CITY OF ALBUQUERQUE

Re: Car Crafters, 5404 Edith NE,
Request for Permanent C.O. – Not Accepted
Engineer's Stamp dated: 12-21-11, (F15/D036)
Certification dated: 08-11-12

KEYED NOTES:

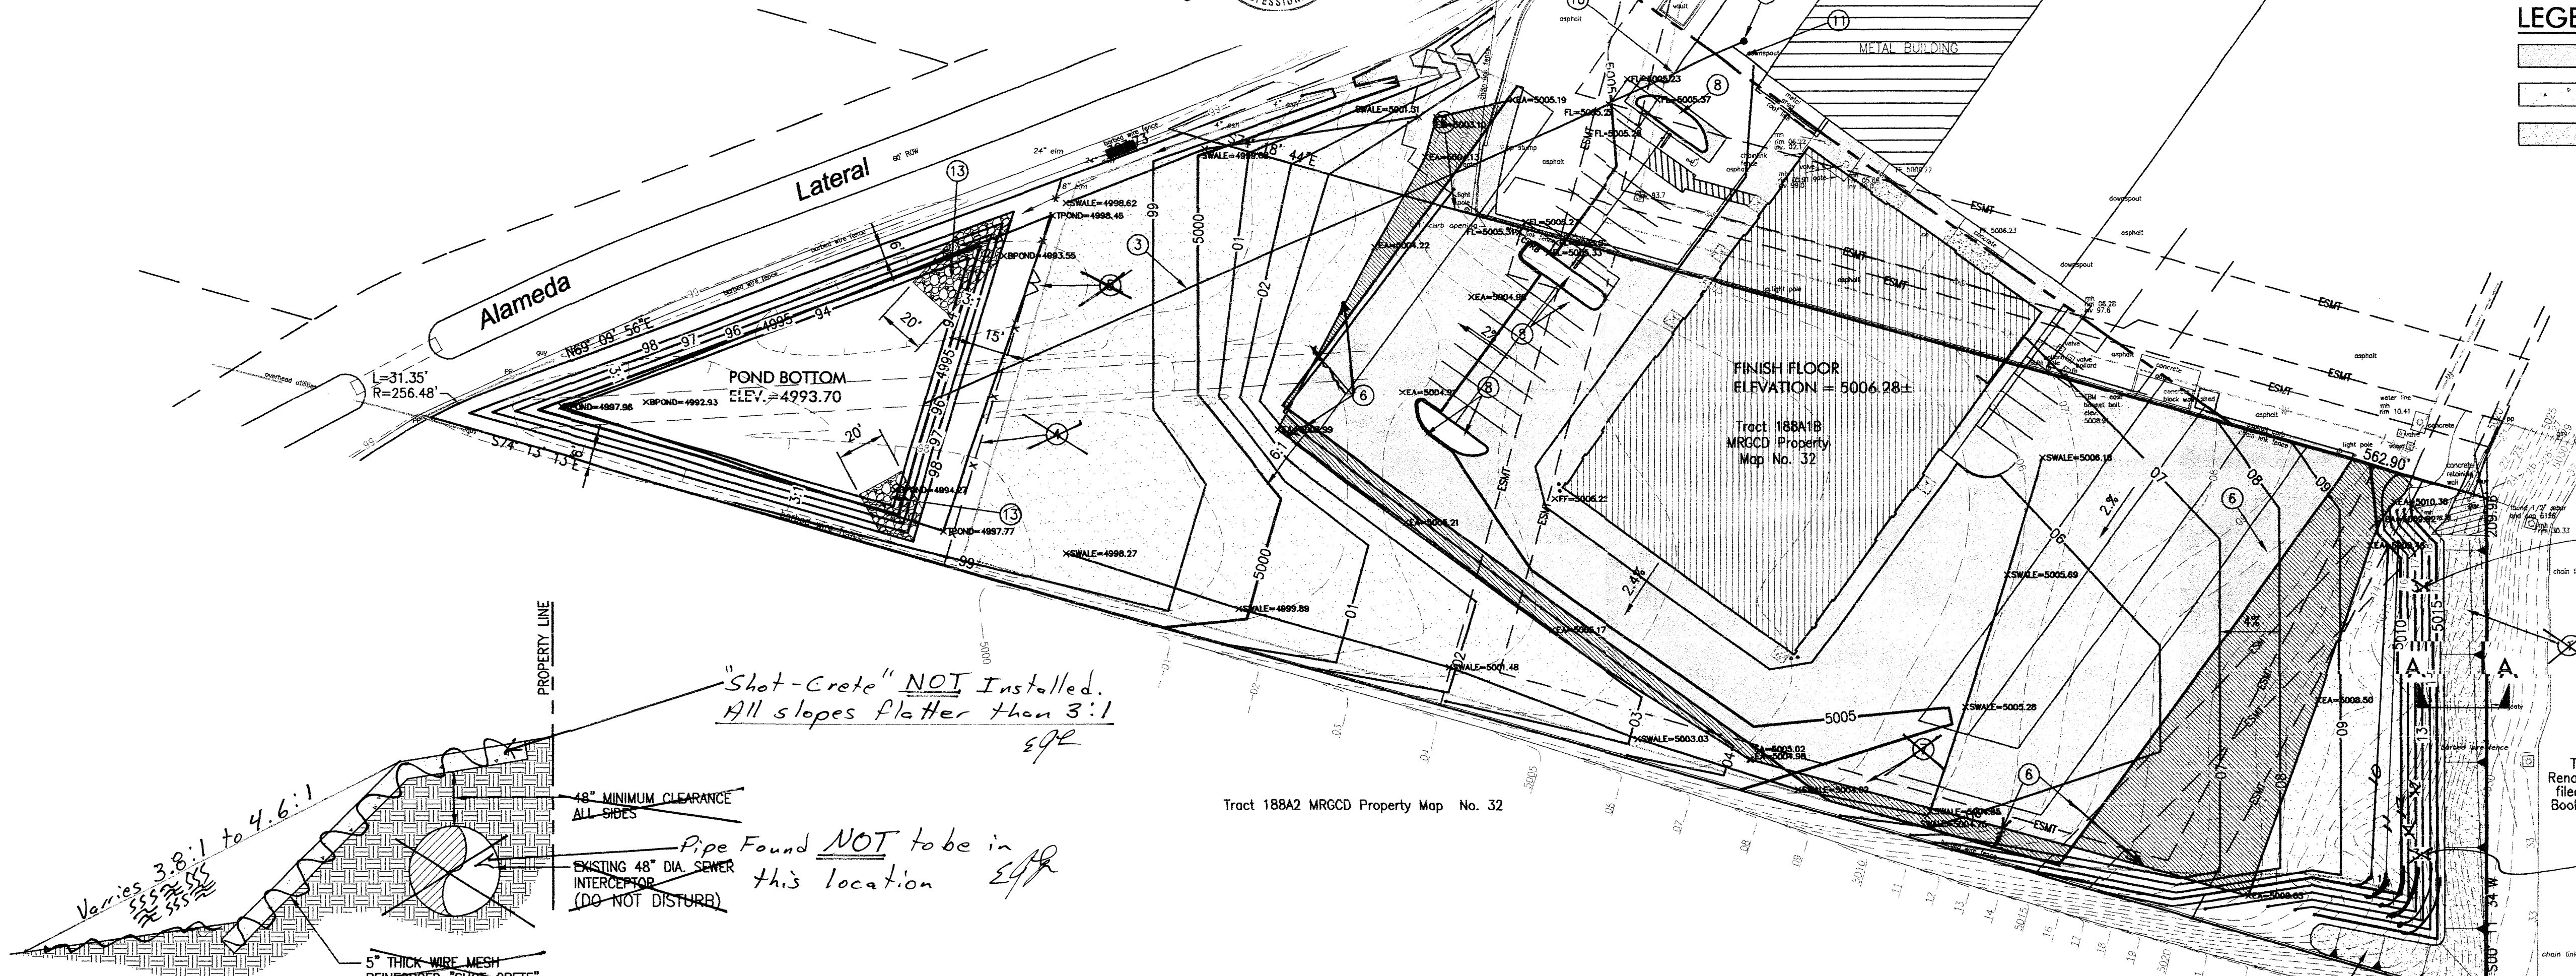
1. The eastern slope will require Shot-Crete per keyed note #1.
2. The plan should reflect current site conditions. Please indicate all details not constructed and show which keyed notes that are deleted or not used.
